Application No: M/91/21/PL
Site Address: 27 Central Drive Middleton-On-Sea PO22 7TT
Description of works: Variation of condition 2-approved plans & removal of condition 4-materials included on plans imposed under M/25/19/PL.

Re: Planning Application M/91/21/PL 27 Central Drive, Elmer, Middleton-on-Sea PO22 7TT.
Variation of condition 2 approved plans and removal of condition 4 materials included on plans imposed

TITLE First Floor Plan

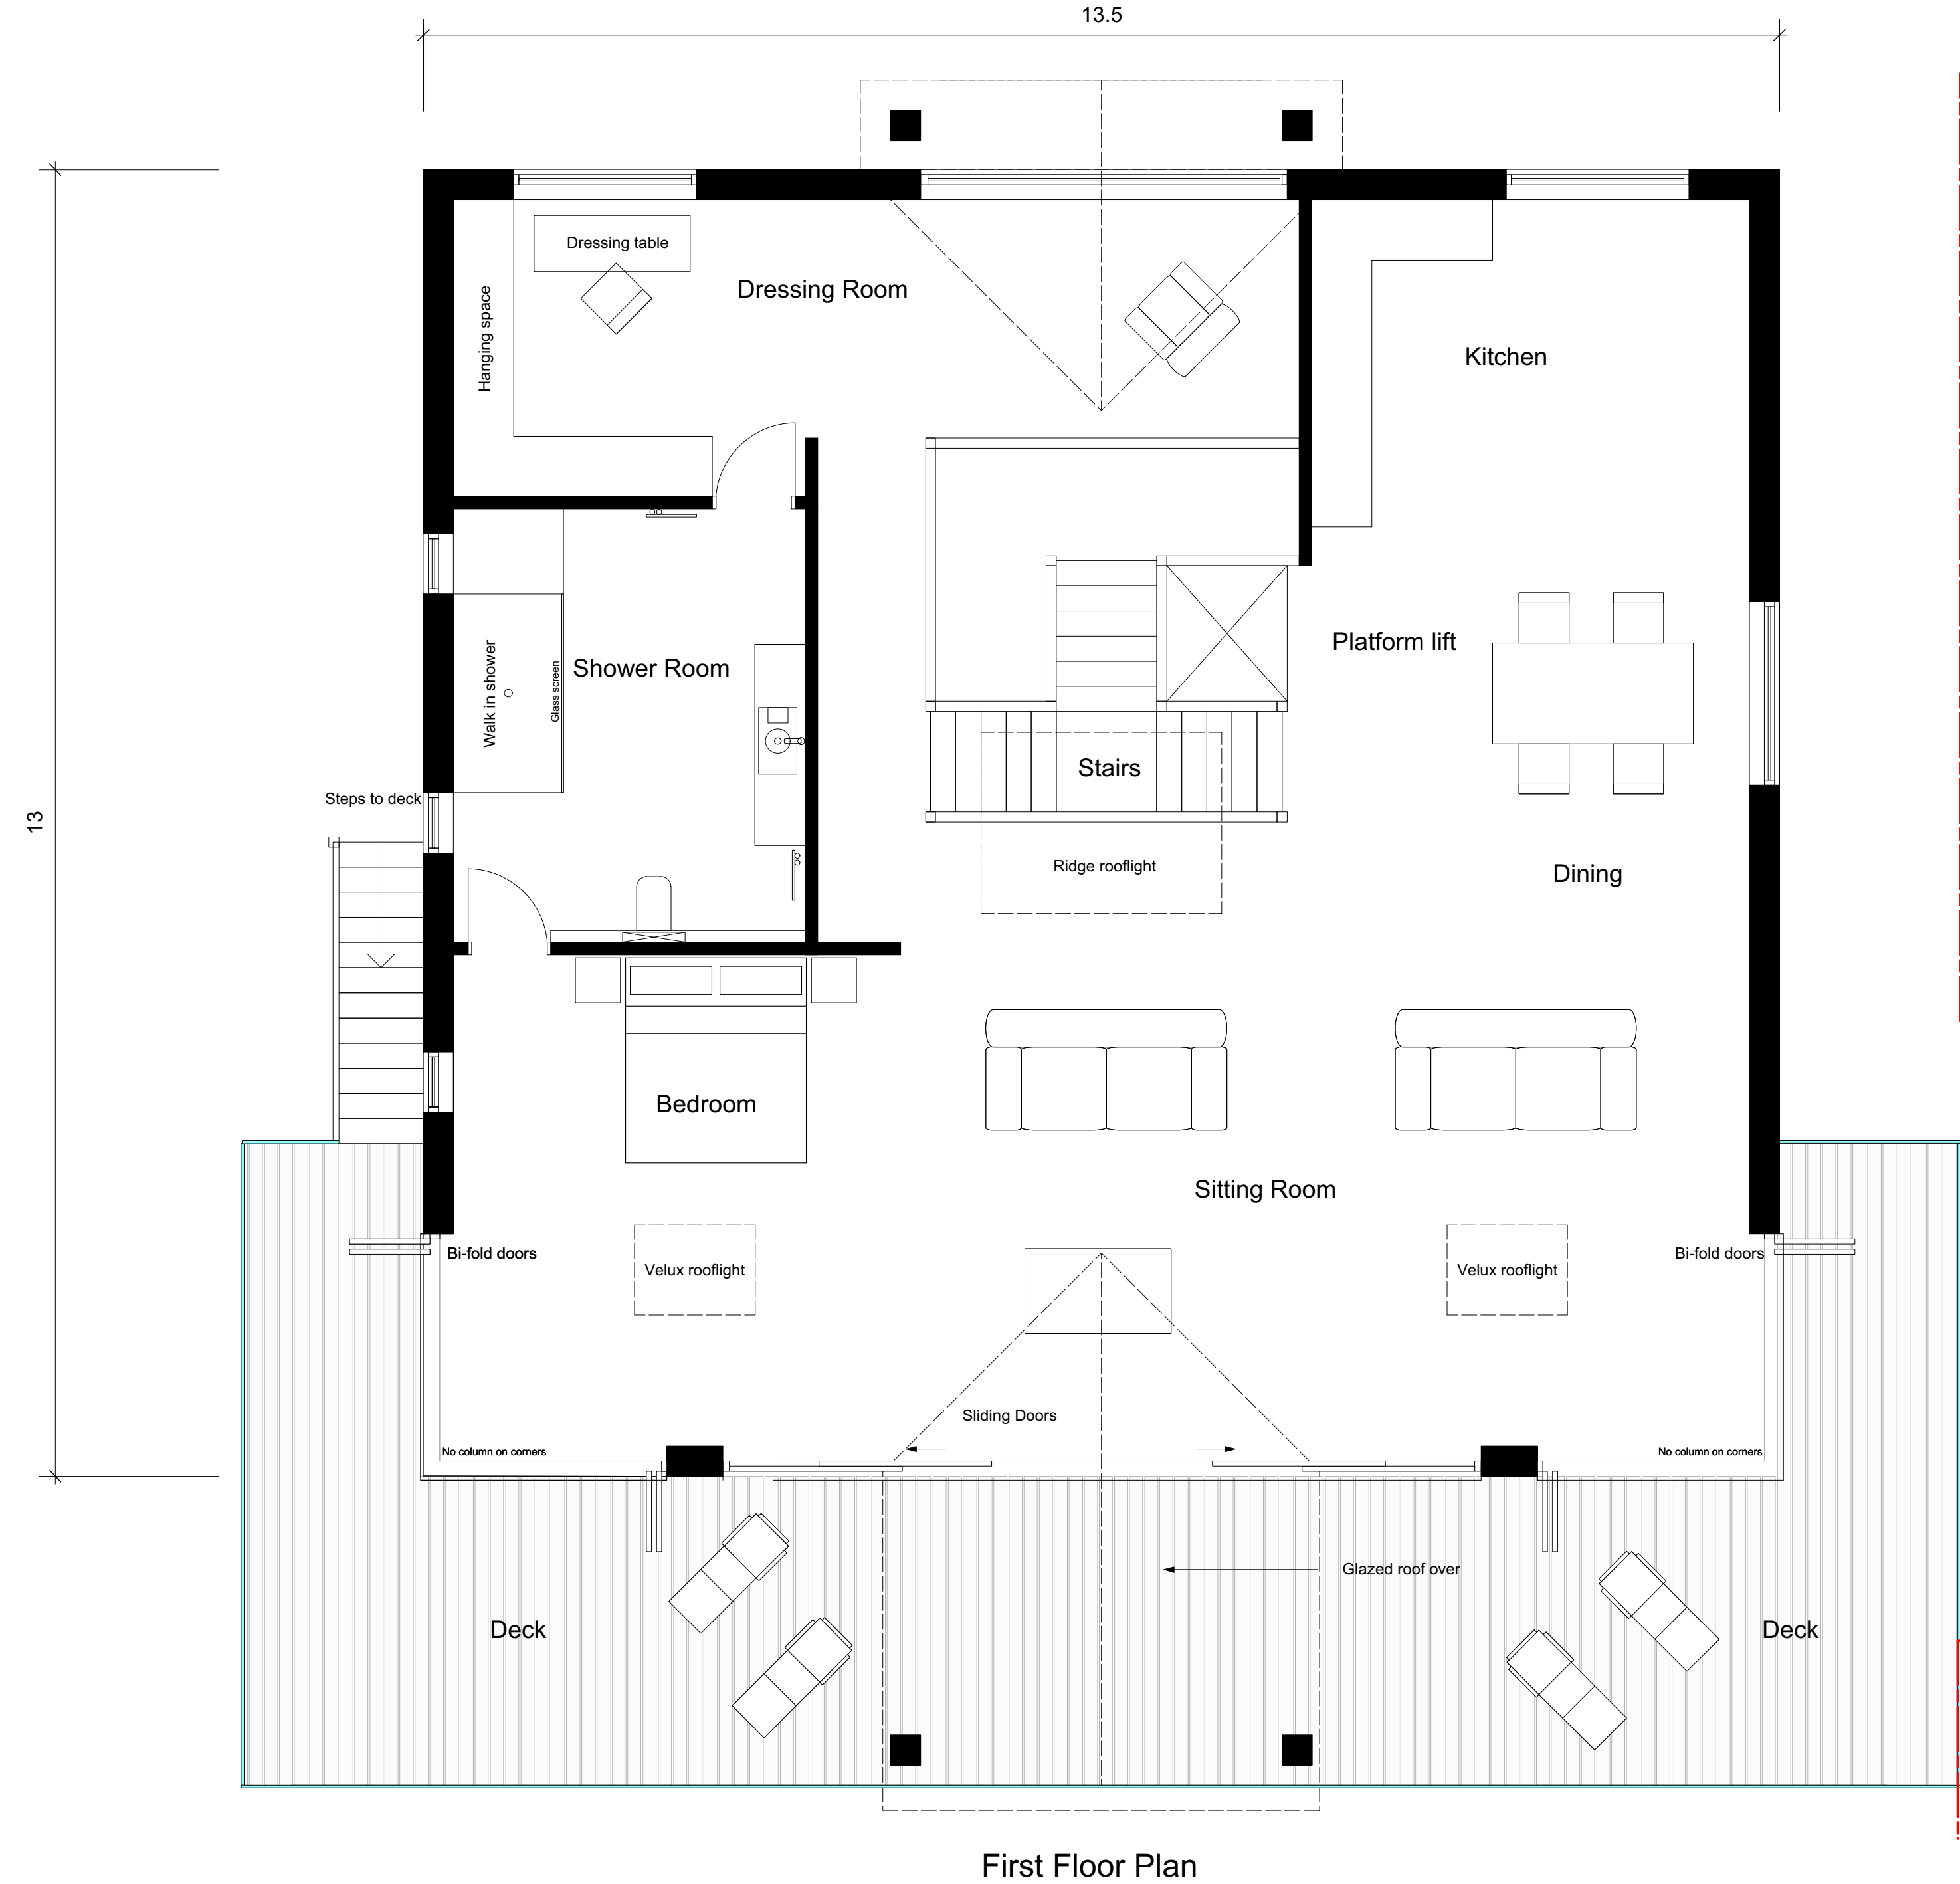
- Removal of the street scene elevation from the list of approved drawings to which the application relates
- Amend the approved first floor elevational plan to show the privacy screen in the correct location and at a height of 1.8m (Note the first floor plan and the east elevation do not currently coincide)
- Amend all relevant plans to remove the link extension between the new dwelling house and No 25 Central Drive
- Include changes to some windows/roof lights no longer required together with minor changes to the approved drawings
- Amend the relevant plans to include details of the proposed materials and finishes for the development.
